**Nyewood Estate & Sunnydale Park Estate
Residents Association**

Objection to planning application BR/201/21/PL Richmond Avenue PO21 2YG

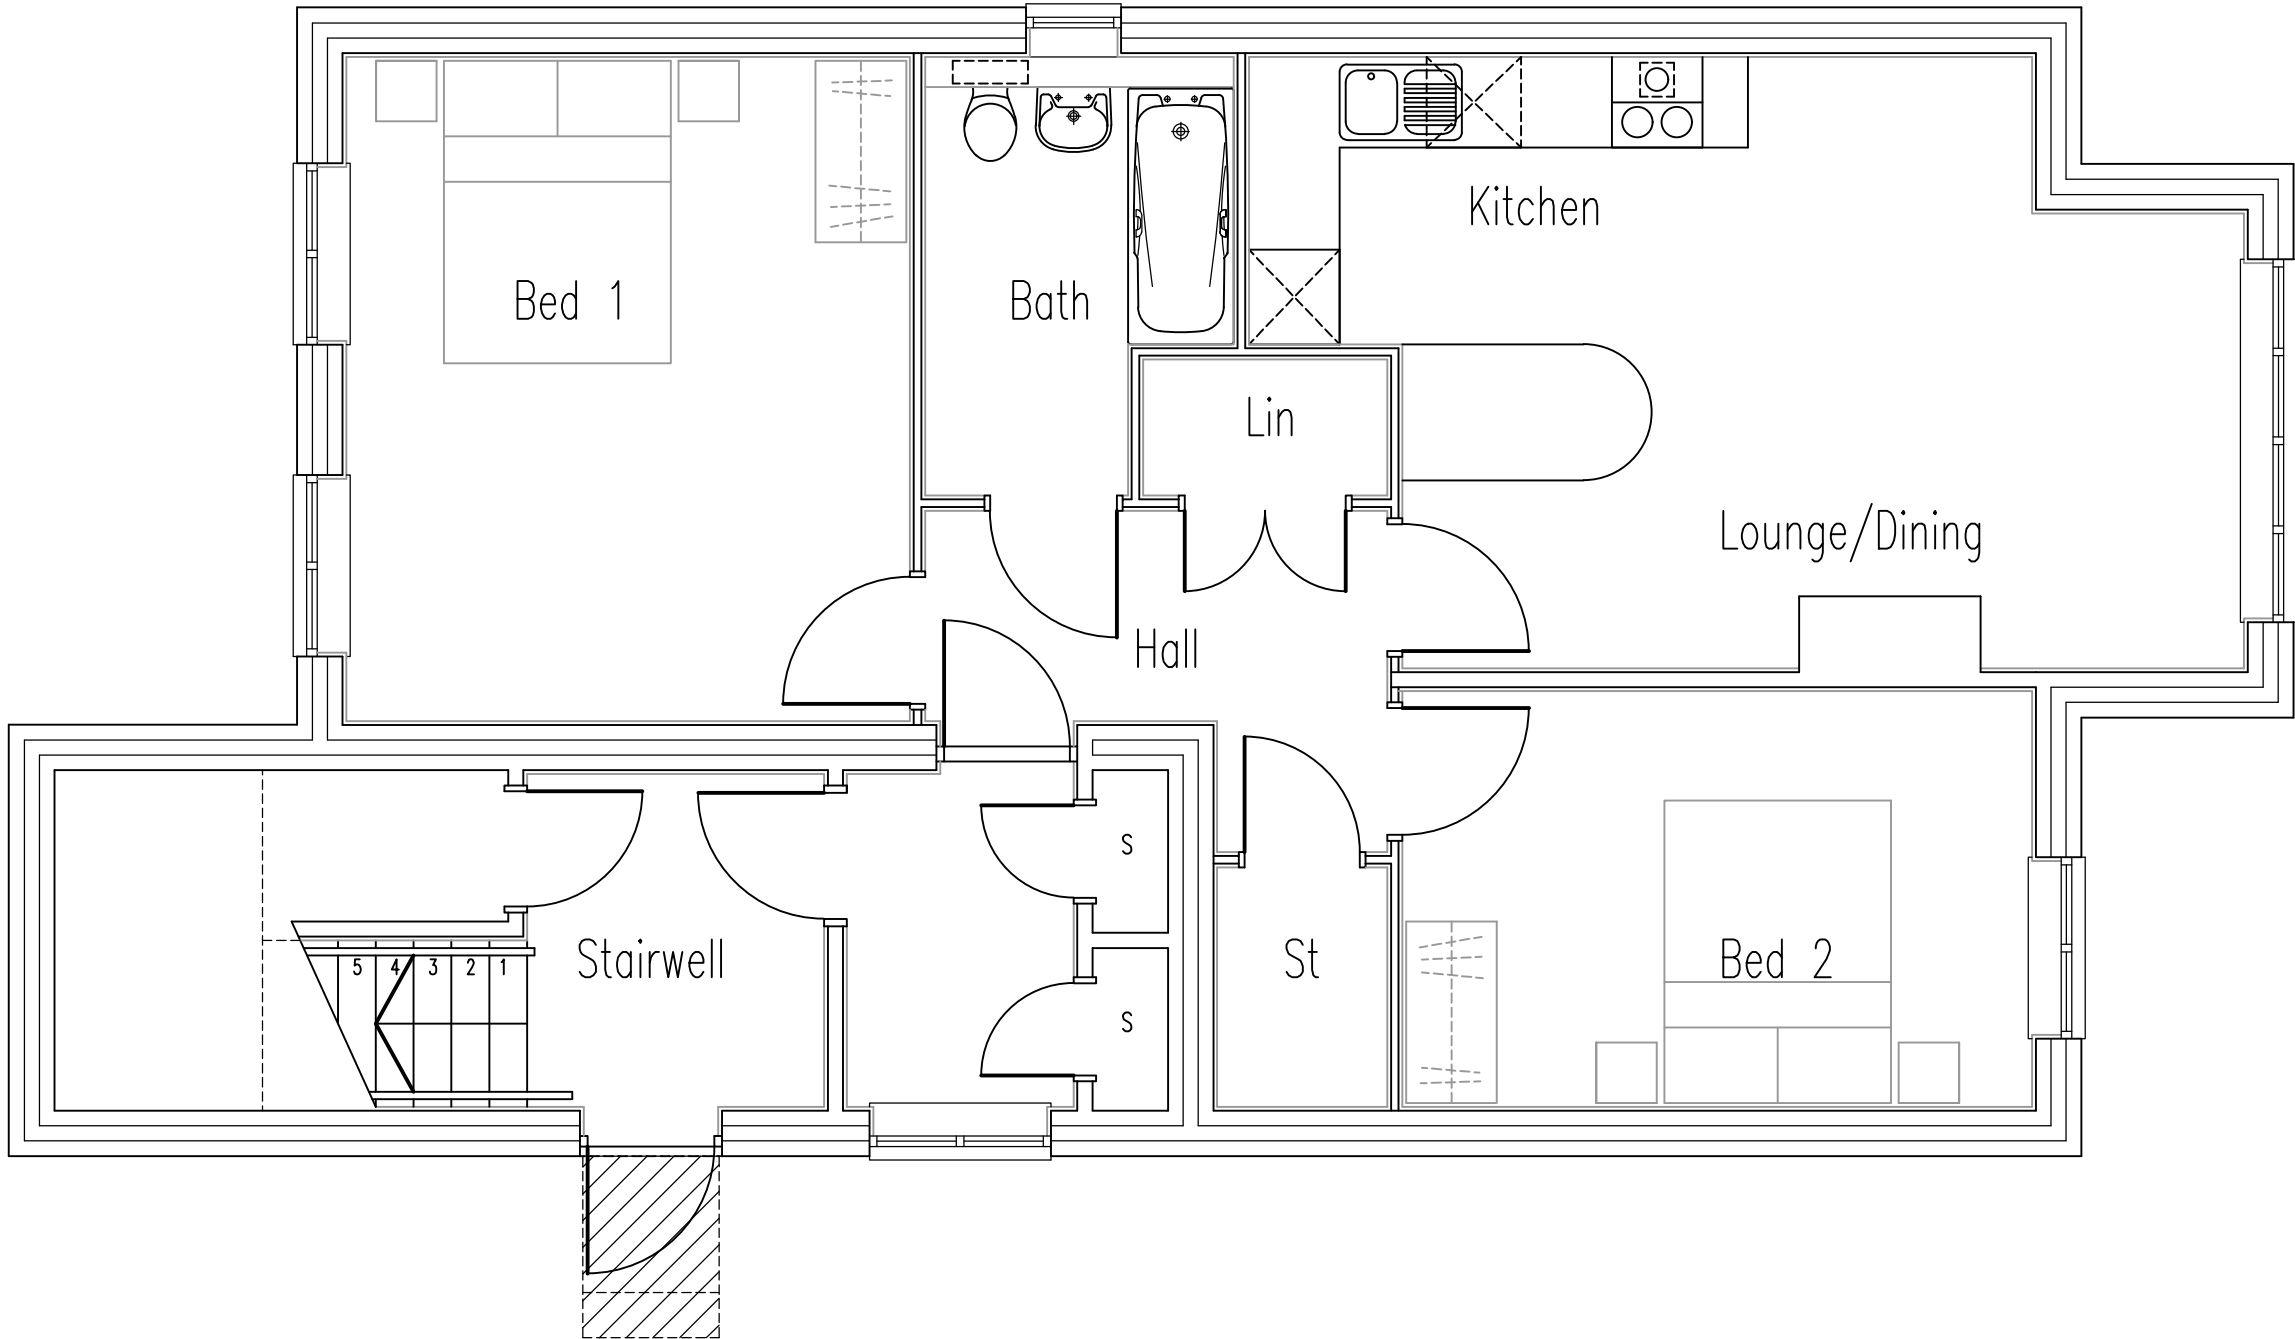
The new proposal being identical in size and impact as the previous one. The new proposal does nothing to address the comments made in the previous refusal. The addition of the 3 parking spaces actually detracts from the 'adequate area of amenity space' which was a specific reason for failure for the previous application.

The new proposal appears to shift the position marginally to the north on the proposed site plan compared to the previous. Despite this repositioning, the building would still 'create unacceptable living conditions for the occupants of adjoining properties' and actually increase the issue of 'being overbearing to Ravenna House' which was a specific reason for failure for the previous application.

The provision to the three parking spaces does not sufficiently address the potential for additional road parking by the occupants. While this assumes one car per flat, if there are 2 people living in each flat and they all have cars then that is a further 3 cars that will be parked on the road. Then, if the occupants have visiting guests that wish to spend a day at the seaside, then that is a potential additional 3 cars parked on an already congested street which already has clear and present issues regarding emergency vehicle access. We note in the supporting documentation as part of the proposal that the applicant agents refer to 'masses of on street parking availability'. This fails to consider the effect of seasonal visitors to the seaside who are all predisposed to park as close to the shore as possible. It is not uncommon to see Richmond Avenue West with parked cars bumper to bumper down both sides during the summer months which would make a fire engine's access virtually impossible. Additionally, we did not see the provision of the electric charging points required for all new build applications.
